Response to Planning application from Hertfordshire County Council (T and CP GDP Order 2015)

District ref: 6/2024/1342/RM
HCC ref: WH/21768/2024
HCC received: 26 July 2024
Area manager: Manjinder Sehmi
Case officer: Matthew Armstrong

Land to the north east of King George V Playing Fields Northaw Road East Cuffley EN6 4RD

Approval of reserved matters (appearance, landscaping, layout, and scale) following outline planning permission S6/2015/1342/PP as varied by 6/2023/1352/VAR for residential development of 10 dwellings and associated infrastructure

GF Site Plan	
Originator project ref 1404	Purpose of Issue For Planning
Scale(s) 1:200	Drawn By AG
Paper size A1	Checked By RS
	Revision description Planning Issue
project originator volume level type role number 1404-GSA-SW-00-DR-A-1300	revision P11

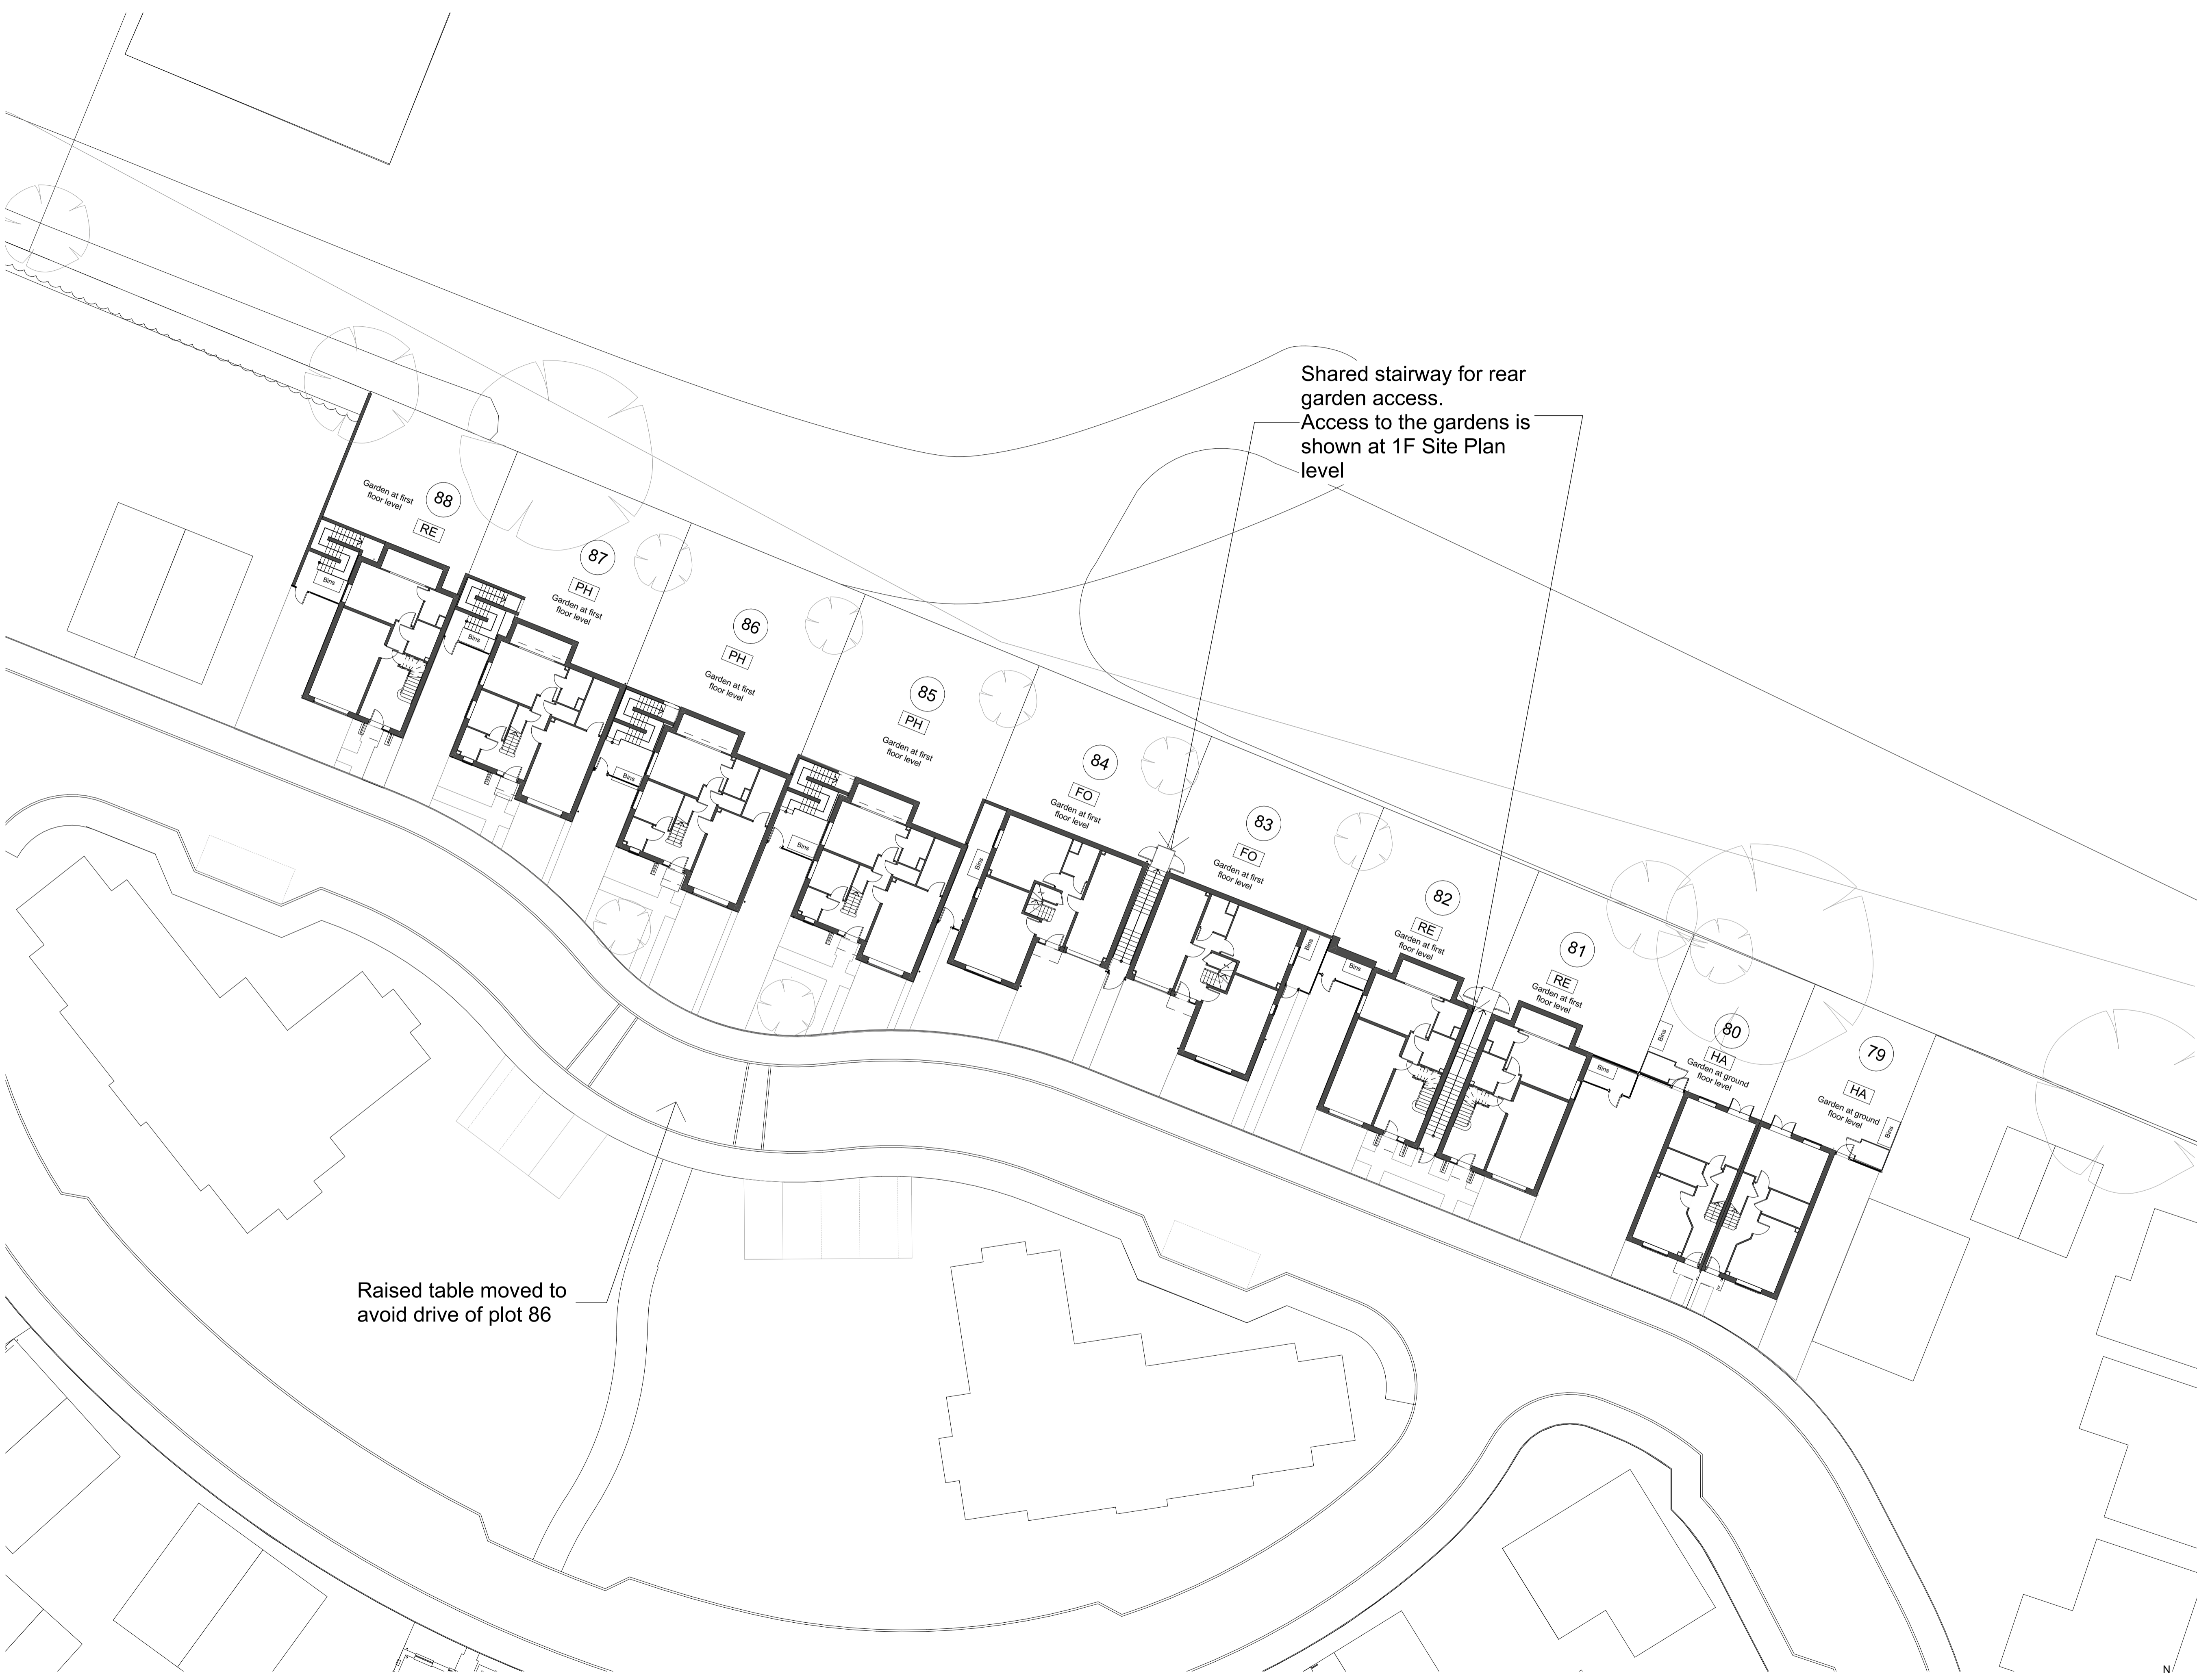
This reserved matters application relates to 10 dwellings on the site, for which amendments are proposed in their designs. In a broad context there are no issues for the public highway as a result of this, but I do note that the parking spaces opposite these 10 dwellings (by the two blocks of flats) appear to have been shifted slightly. This means cars entering and exiting some of these spaces will do so directly on the riser sections of the raised tables (this was avoided in the originally approved reserved matters application). However, whilst this is not best practice (as it can create an uncomfortable up-down-up profile for car occupants, and might deteriorate the raised table more quickly over time), I am mindful that the Highway Authority will not be adopting these internal roads.
